Sizewell C

Written Submission to Deadline 10

On behalf of Rookery Park LLC

DRAWING TITLE:
 YOXFORD ROUNDABOUT PROPOSED GENERAL ARRANGEMENT

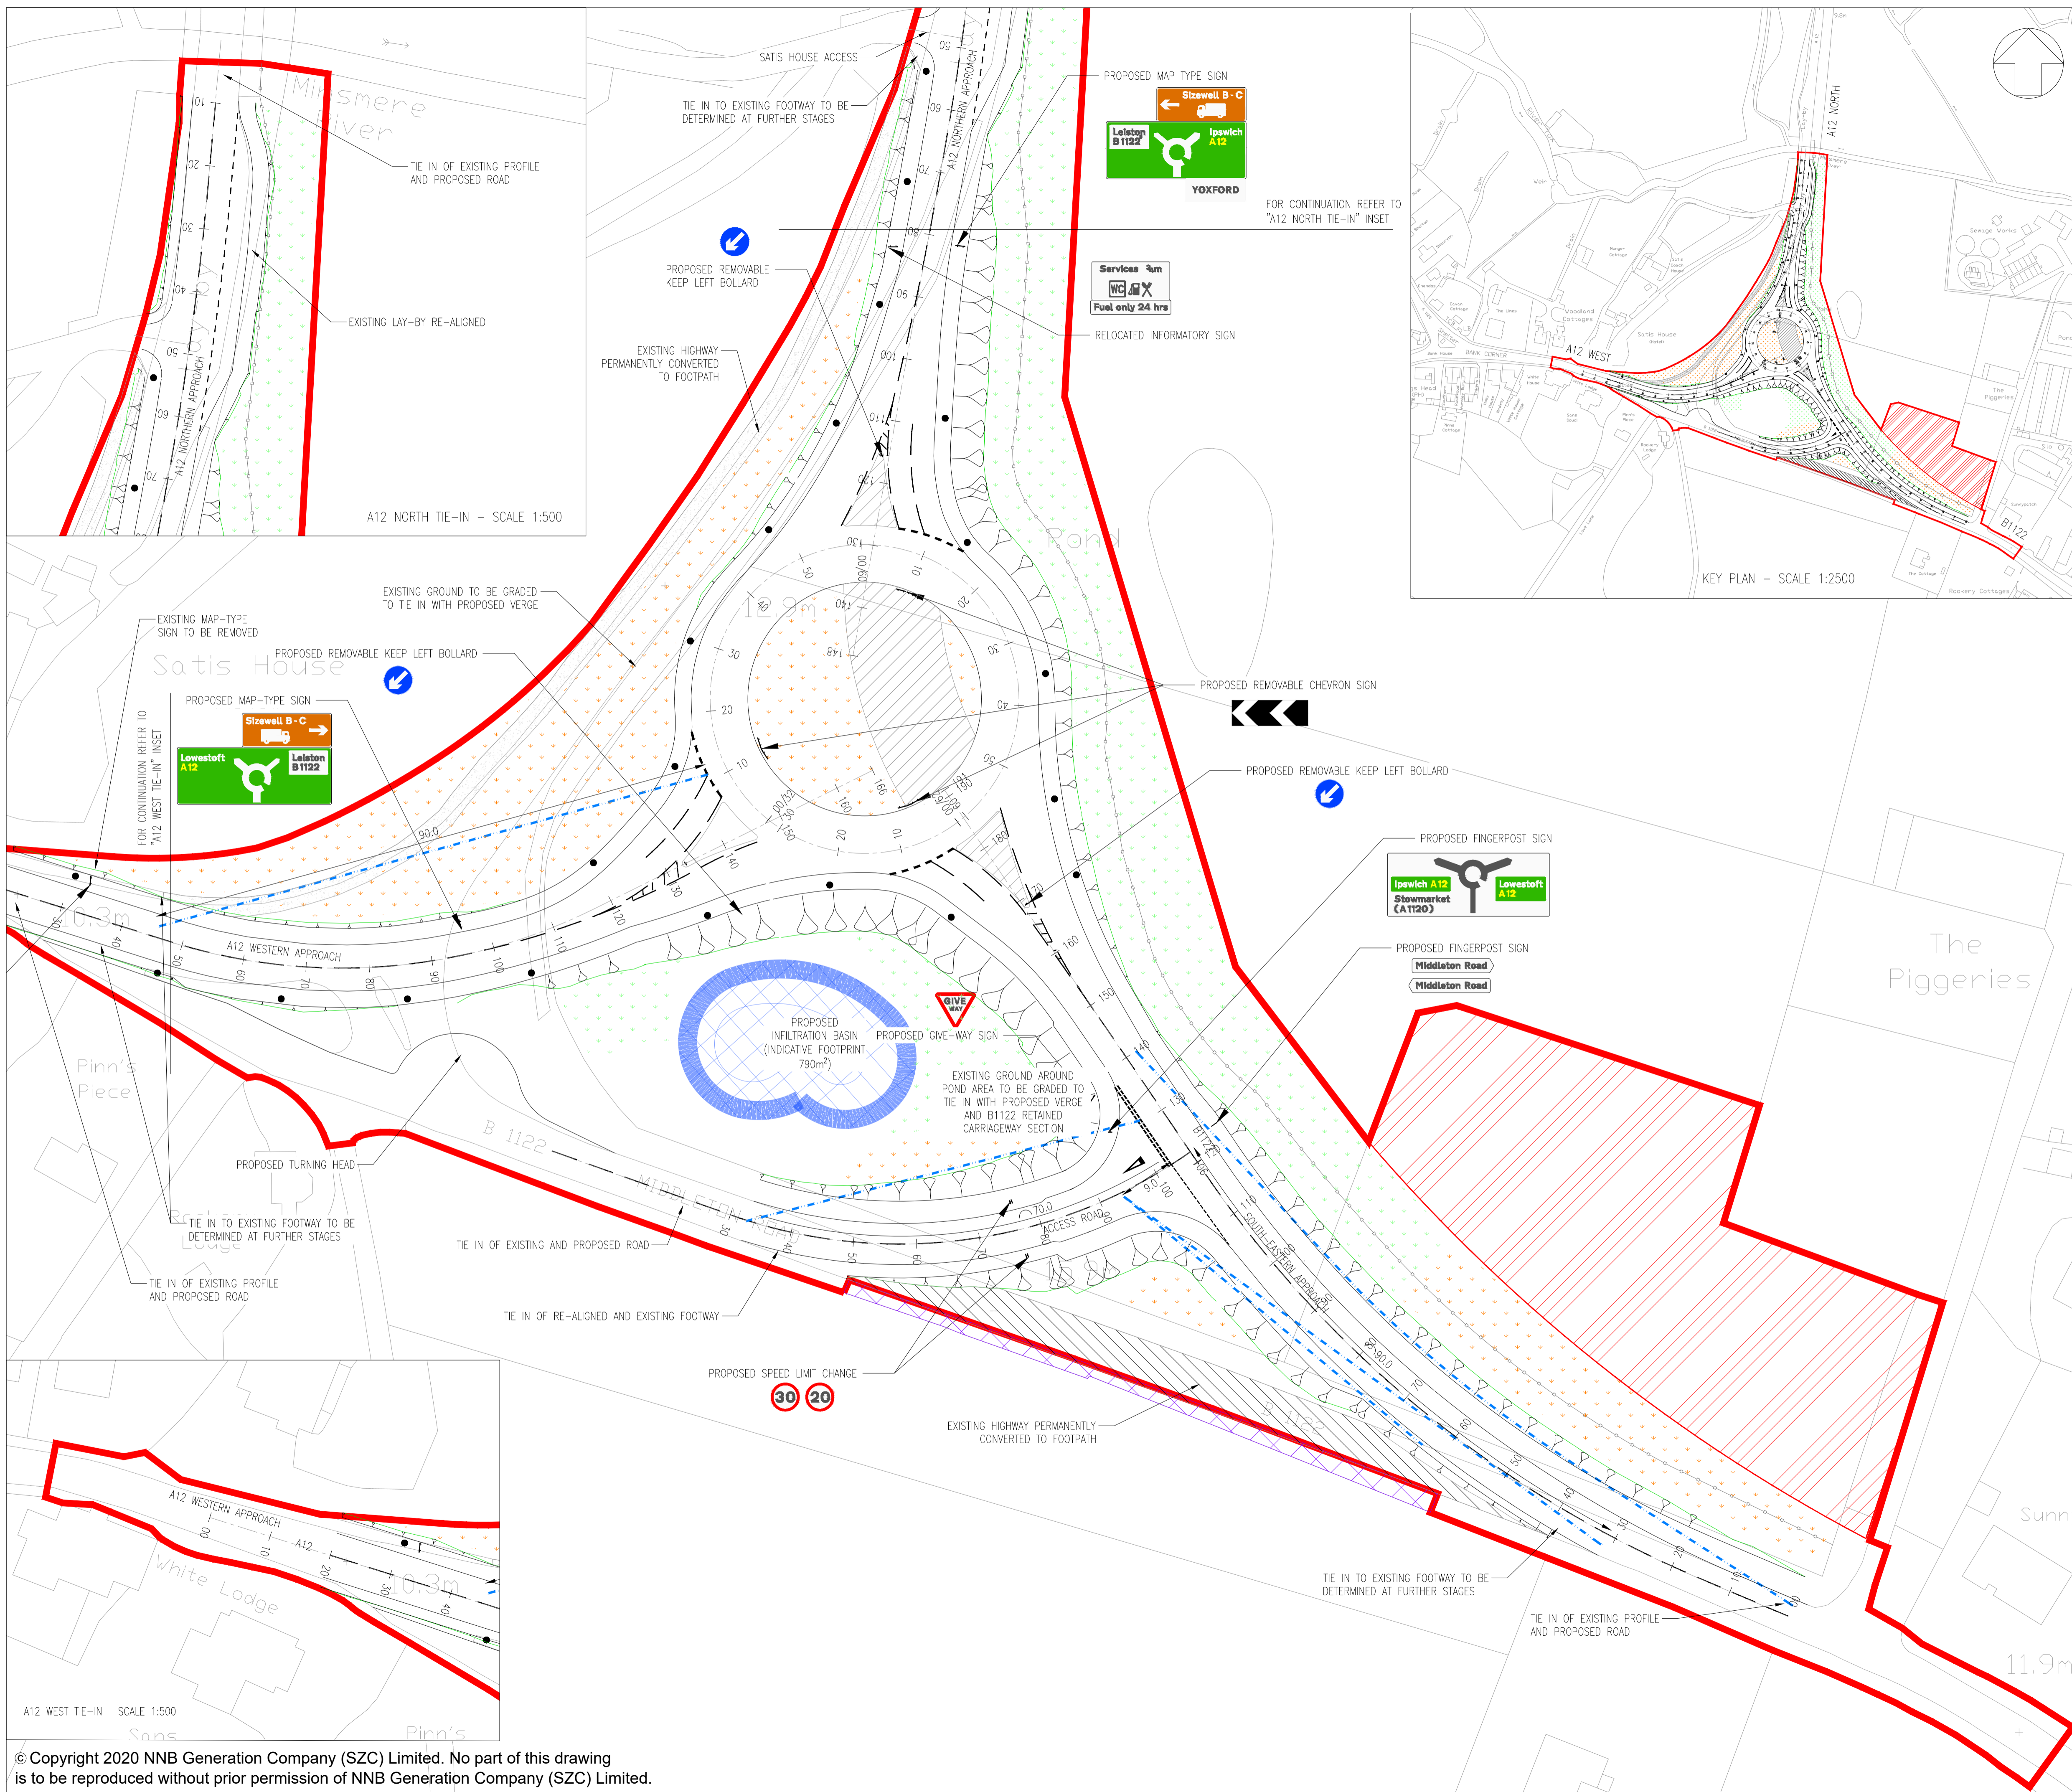
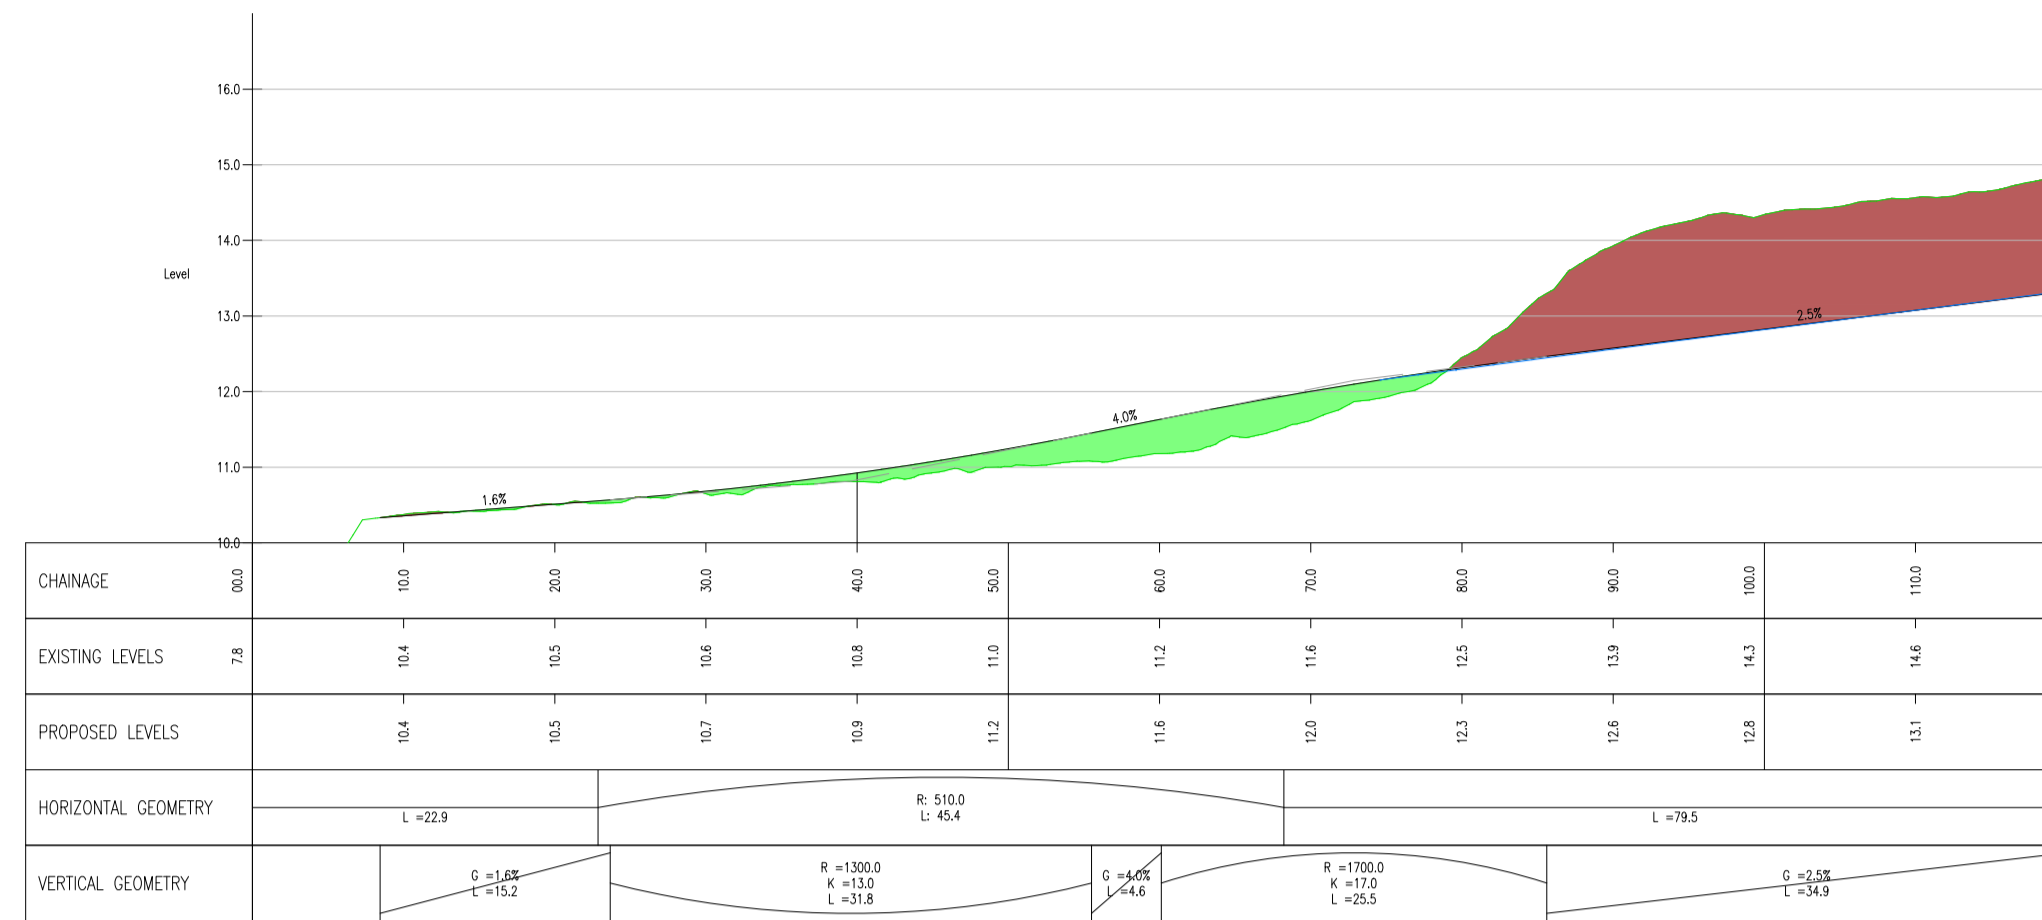
The creation of the proposed roundabout on ground which is higher than the existing junction. This will result in the roundabouts illumination being markedly more visible at our clients property, Rookery Park itself, than the current illumination on the existing A12/B1122 junction. We believe there will be up to 16 lighting columns immediately surrounding the roundabout which will have a significant effect on the extent of the illumination on the edge of the Estate and from our clients view point northwards from Rookery Park

In addition, we ask for further detail on how the roundabout will be constructed to minimise the disturbance to our clients property including two residential properties close to the junction being Rookery Park Lodge and a property called The Cottage, both on the edge of the B1122. An uninterrupted access will be required to these properties at all times.

We are concerned about the boundary treatment along the north of our clients property and beside the re-designed junction to ensure no boundary fences or conservation features are affected by the scheme.

We would also ask, that the appropriate security arrangements are made in relation to the land between the roundabout and our clients property once constructed to avoid illegal trespass, dumping and other anti-social activities.
